**Consultation Response from Mike Hibbert,
KC Waste Strategy(Refuse & Recycling)**

2024/92105 Wesley House, Huddersfield Road, Birstall, Batley, WF17 9AZ

Alterations to convert former offices to 21 apartments (Listed Building within a Conservation Area)

Responding Ref: WPN 24-026

Plan: **Proposed Site Layout and Location Plan**

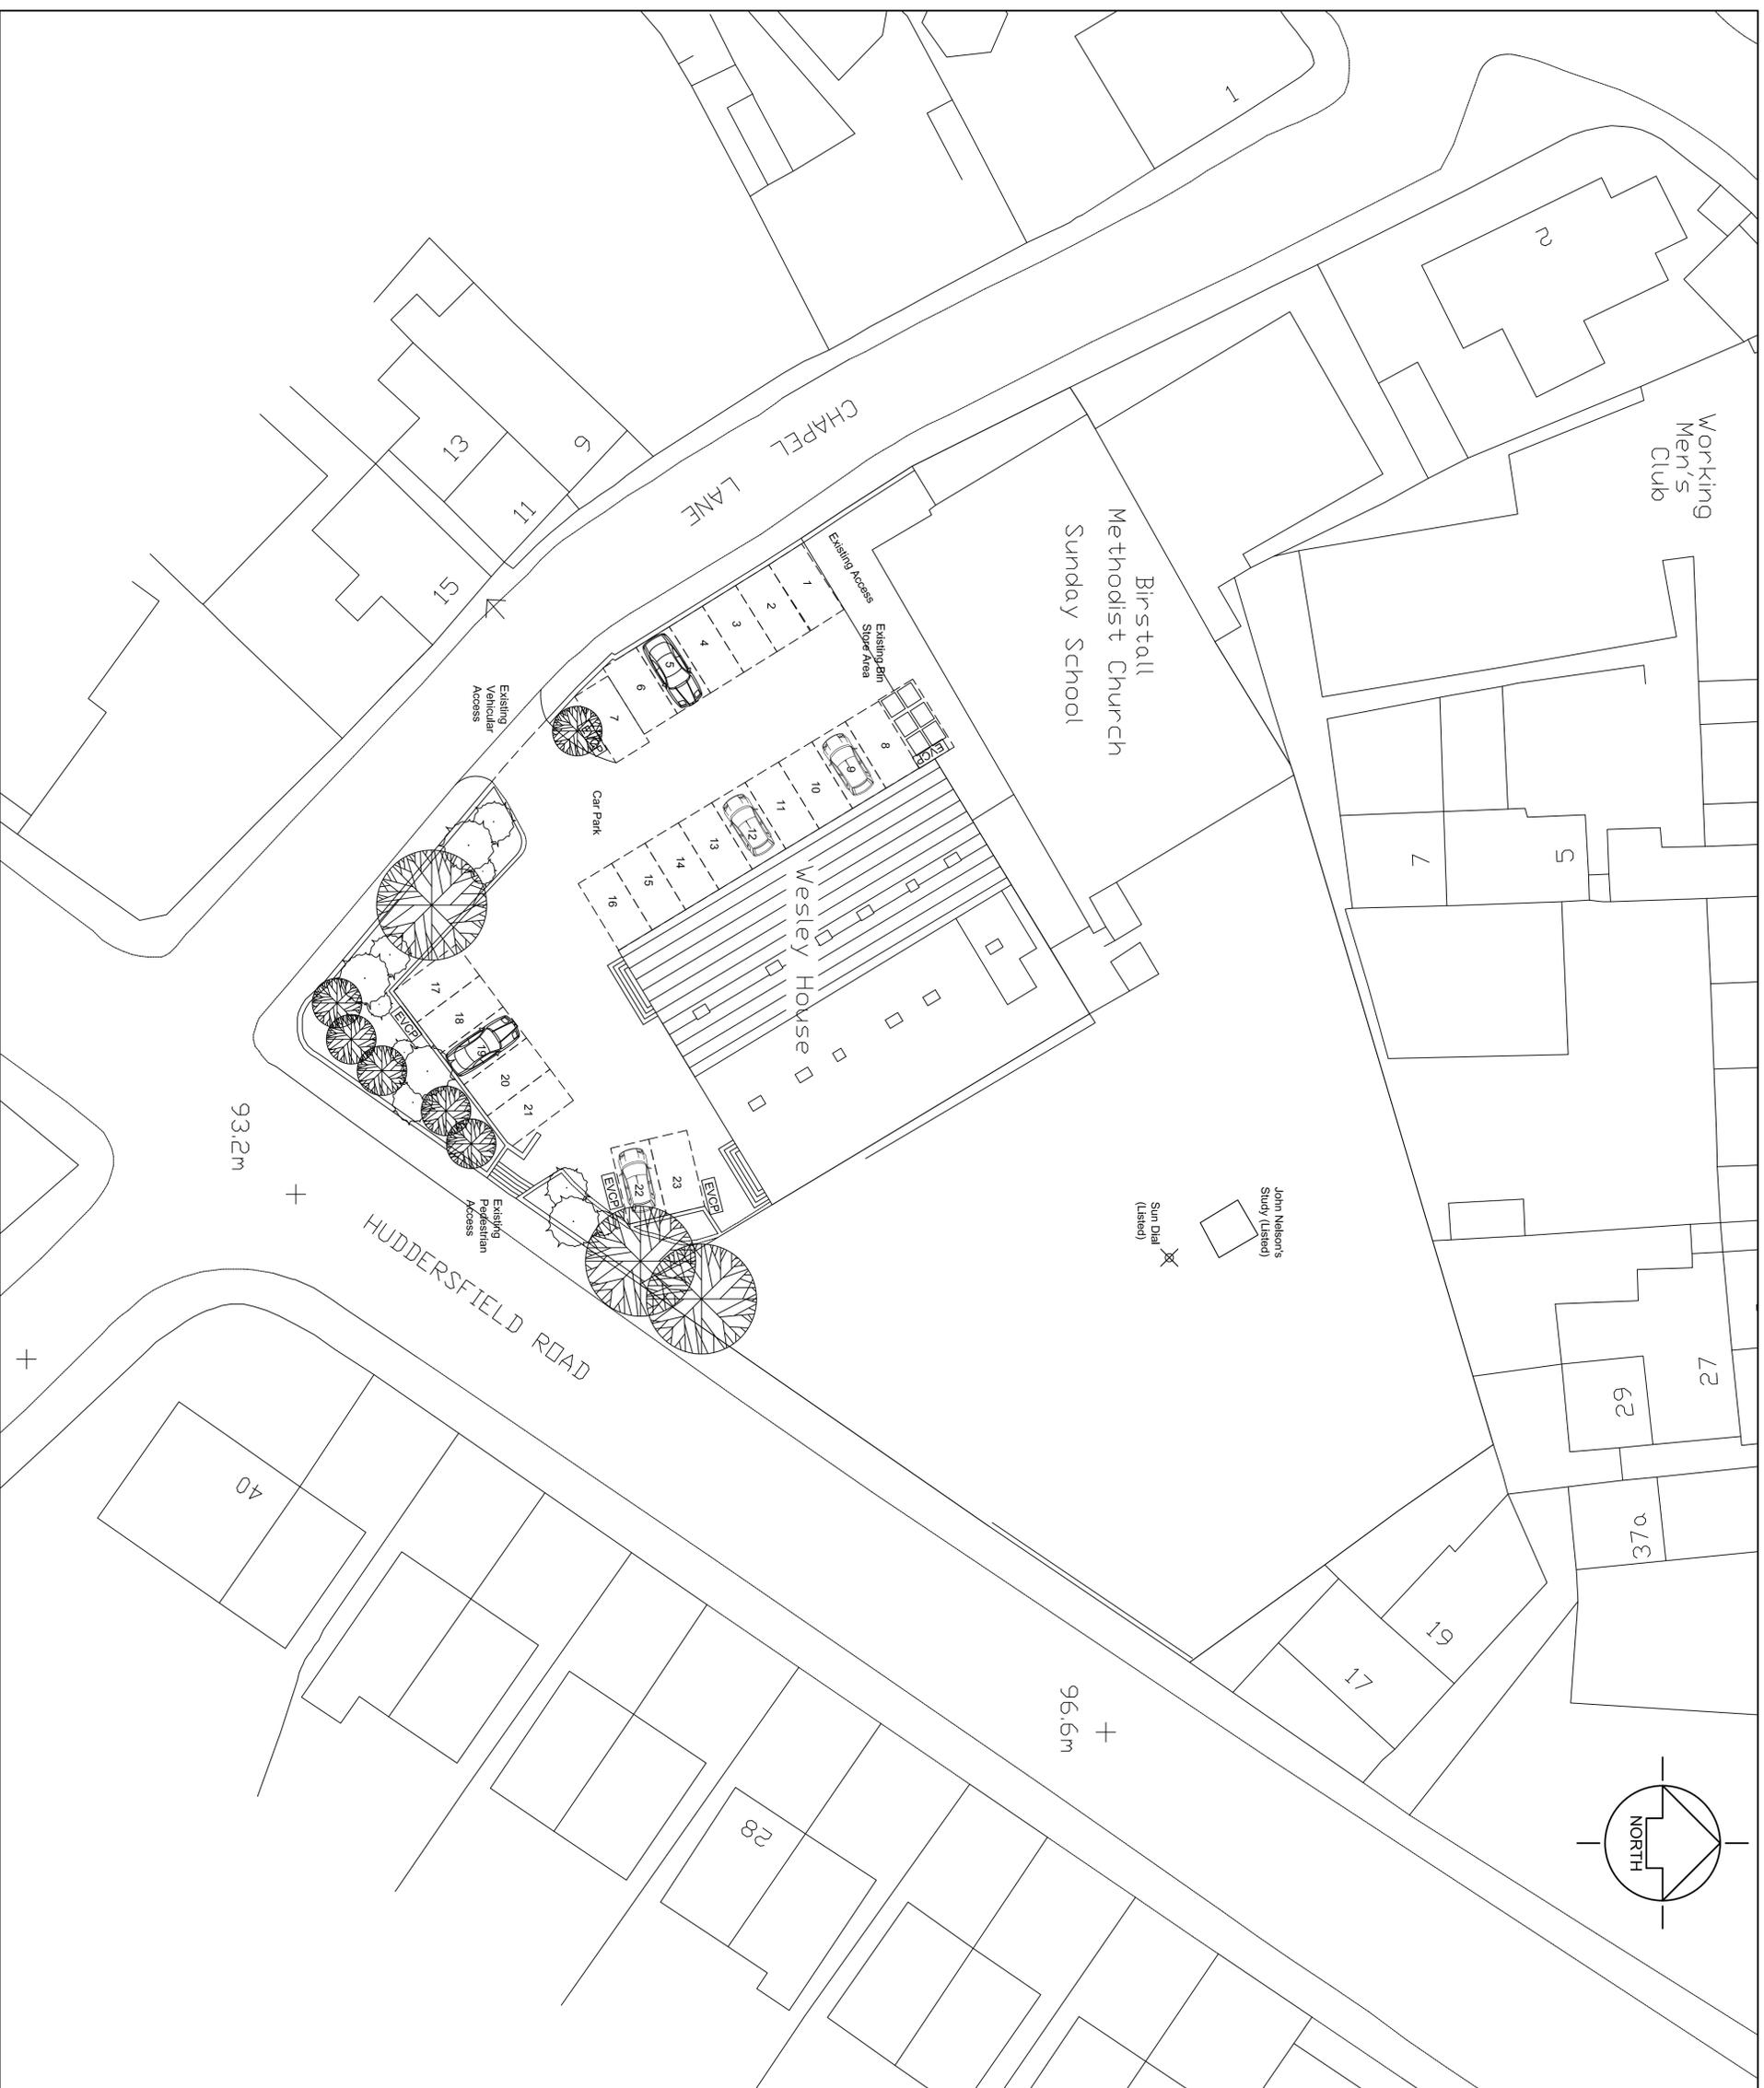
The layout drawing shows the location of a bin store: -

- For 21 apartments individual wheeliebins would not be appropriate. The recommended waste storage provision is approximately 3,780ltrs (21X180 litres) for both residual and recycling bins. Appropriate waste storage provision would be 6 x 1100ltrs wheeliebins. (3x Recycling and 3x residual). Provision should be included for separate collection of food waste to ensure compliance with Government Simpler Recycling legislation.

- The Bin store has approximate dimensions of 2.5m x 4.1m with the six wheeliebins shown as 1250mm x 1000mm. Guidance indicates the floor space for a 1100ltr wheeliebins is 1575mmx1190mm with space to manoeuvre the bins within the store. The bin store layout as shown may be too small and does not show access gates to the store. Additional information is required detailing waste storage, containers, capacity and design of the waste storage compound including, screening, surfacing and security. Appropriate standards are detailed in the Kirklees Waste Management Design Guide 2020. Bin store surfaces should be durable and waterproof enough to withstand heavy duty cleaning such as power washing.

- The walk distance from the entrance points of the apartments to proposed bin store should be less than the 30m maximum specified in guidance BS5906:2005. This should be achievable within the site.

- To reduce the drag out distance from the bin store to the highway but still be within the 30m walk for residents it would be appropriate to relocate/ swap the existing bin store to Parking Space No7 or No17 as shown on the plan.

- Waste storage should address the fire risk issues presented by large quantities of waste – **it must be either 6m away from the building or be constructed of suitable material to contain and prevent the spread of fire.** See BS5906:2005, Building Regs 2010 Part H6 and CFPA-E Guideline No 7:2022 F.

- The bin storage area and access routes to the Bin Collection Point (BCP) should be constructed to withstand point loading and movement, impacts of larger bins over time, and to resist future rutting, pitting, cracking or other such surface degradation that would impair bin manoeuvring. To facilitate loading of full wheeliebins the surface between the bin store and BCP/ highway should be smooth hard surface without kerbs. Maximum drag out distance should be less than 8m. The proposed layout must ensure that parked cars do not obstruct the route between the bin store and loading point.
